**ECE Architecture  
Brooklyn Chambers  
11 Goring Road  
Worthing**

Your Ref :  
Our Ref : EP/61/13/NMA

**Application for a non-material amendment following a grant of planning permission EP/21/10 -**  
**Regency style ornamental gates added to entrance of development in addition to ornamental**  
**metal railings between brick piers with stone caps & pedestrian access gate with corresponding**  
**access path**  
**Nursery Close, Manor Road, East Preston,**

Drawn	Checked	Date
NS	AK	04.03.13
Job No	Drawing No	Rev
5408	L(90)010	B

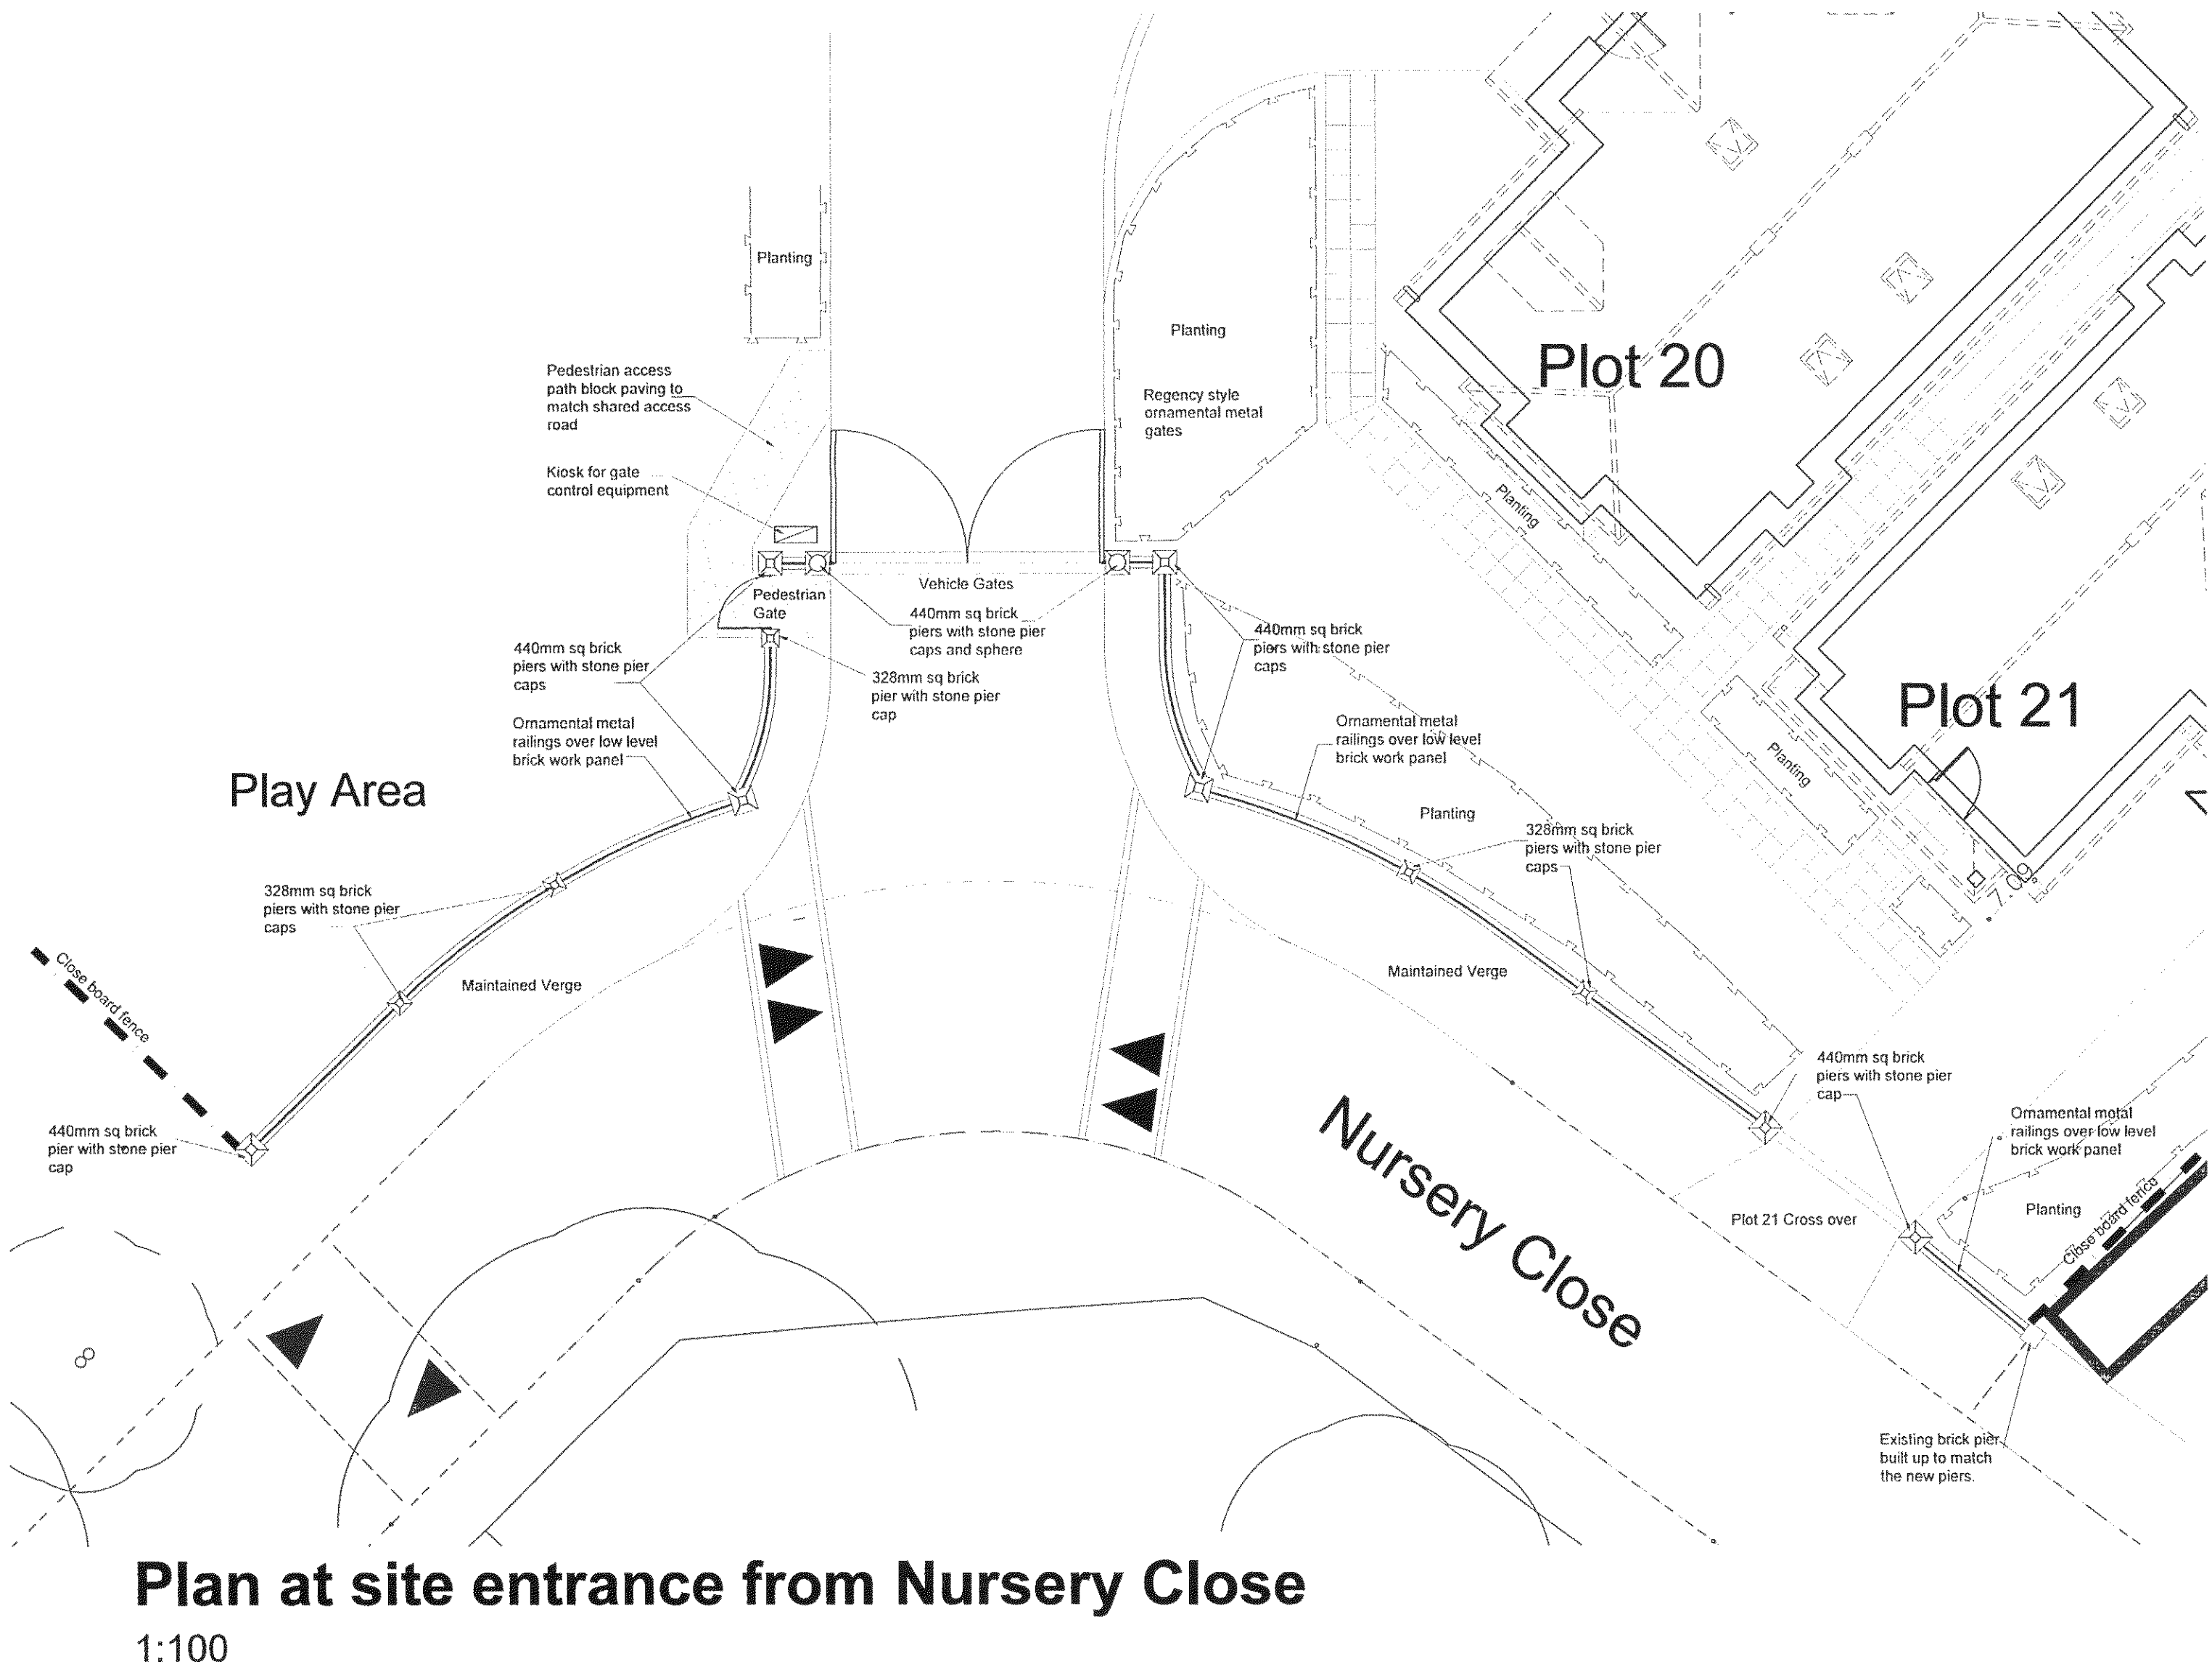
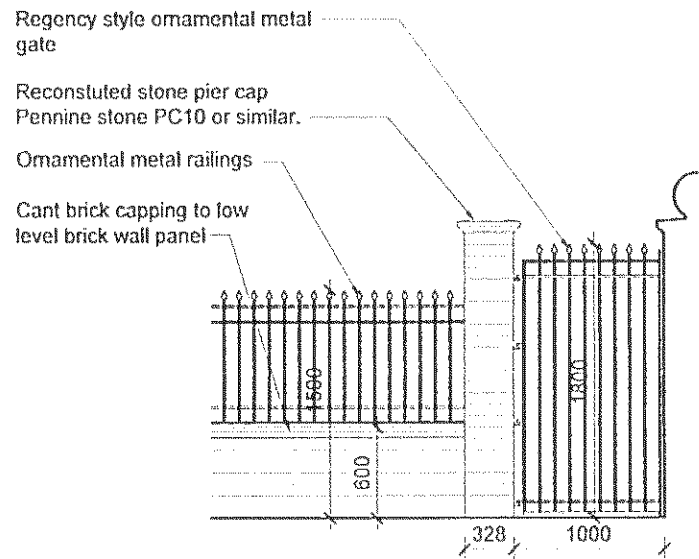
Regency style ornamental gates provided at entrance to development in lieu of those previously approved, addition of metal railings between piers with stone caps on top of approved wall and additional pedestrian access gate and path.

This is on the basis that the change in appearance of the boundary demarcation in the street scene is not material. Please note that drawing no.L(90)010 revB received on 03-05-2013 has therefore become the approved plan for planning application EP/21/10.
